Application No.	2023/93704
Proposed Development:	Erection of 12 dwellings and associated works
Location:	land northwest of, Urban Terrace, Denby Lane, Grange Moor, Huddersfield, WF4 4EB
OS Map Reference	SE 422319.5539 416203.7912
Applicant/Agent:	Broadgrove Planning & Development Ltd
Class:	Small Major Developments

Consultation Response from KC,  
Landscape - Emma Mills

Date Responded: 21.11.2024  
Responding Officer: Landscape  
Responding Ref: MM126

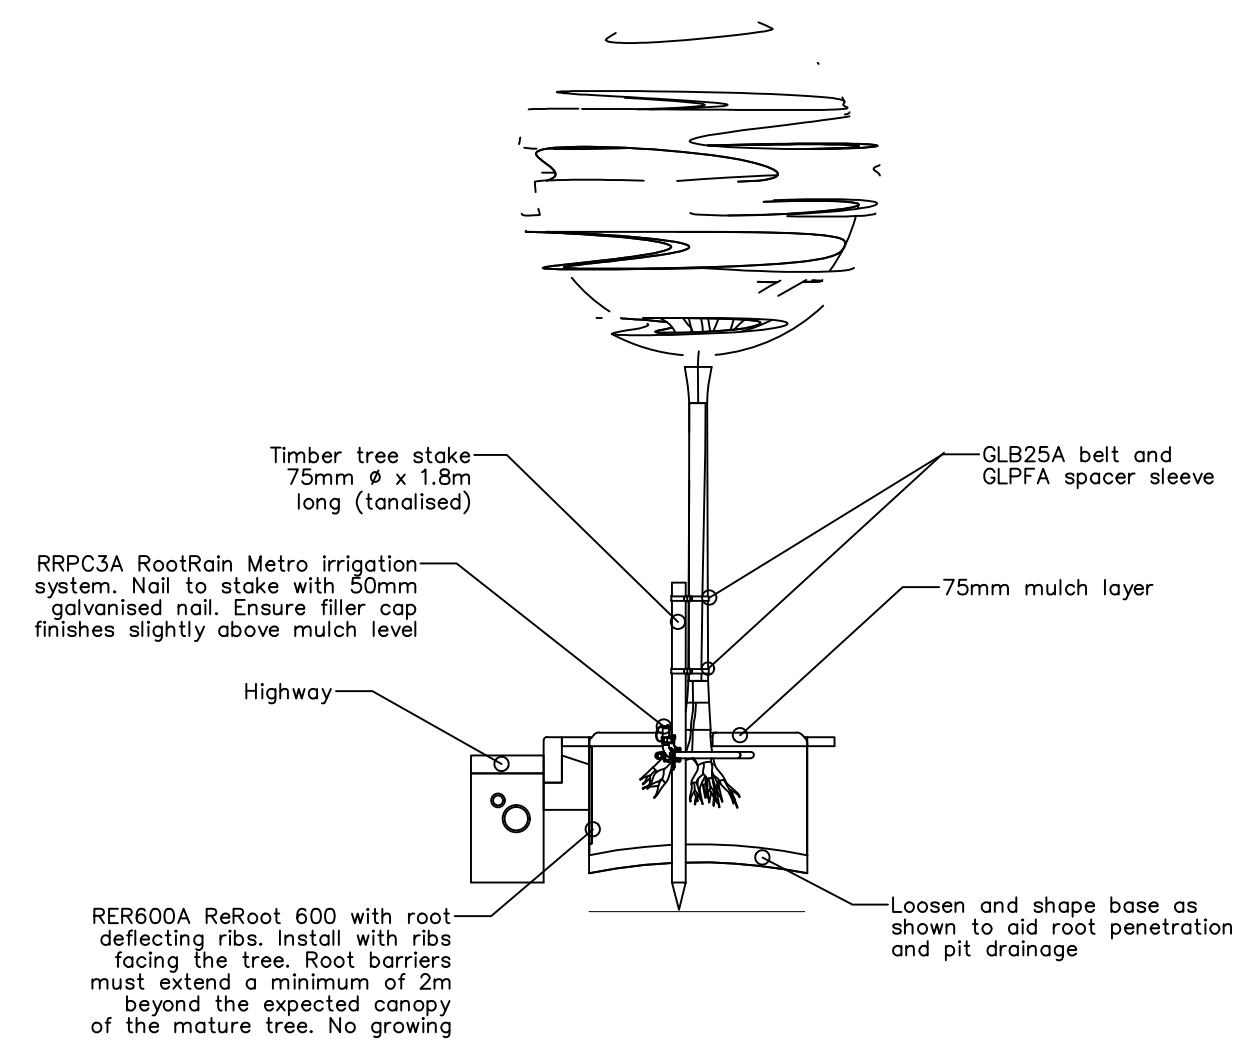
The landscape key now includes the proposed wildflower mix, which is acceptable, and we presume BNG so needing to be managed and maintained for 30 years as wildflowers.

However, the area in front of plot 5 is a grass verge which does not appear to be accessible public open space for the public to spend dwell time.

Also, the other space has only a mown grass path to the tree seat, which is also not particularly accessible, especially for large parts of the year, with no surface under the tree seat either. The Council has an obligation in respect of the Equalities Act and therefore mown grass paths across open greenspace are not acceptable versus bitmac or bound gravel paths.

We are therefore surprised that the designer has not made the tree seat accessible as the desire line to access the tree seat will no doubt become a muddy path and not particularly welcoming for those wanting to spend time here.

**There looks to be no access to the area over the attenuation tank and this is proposed wildflower mix so is public accessibility for all even anticipated here?**
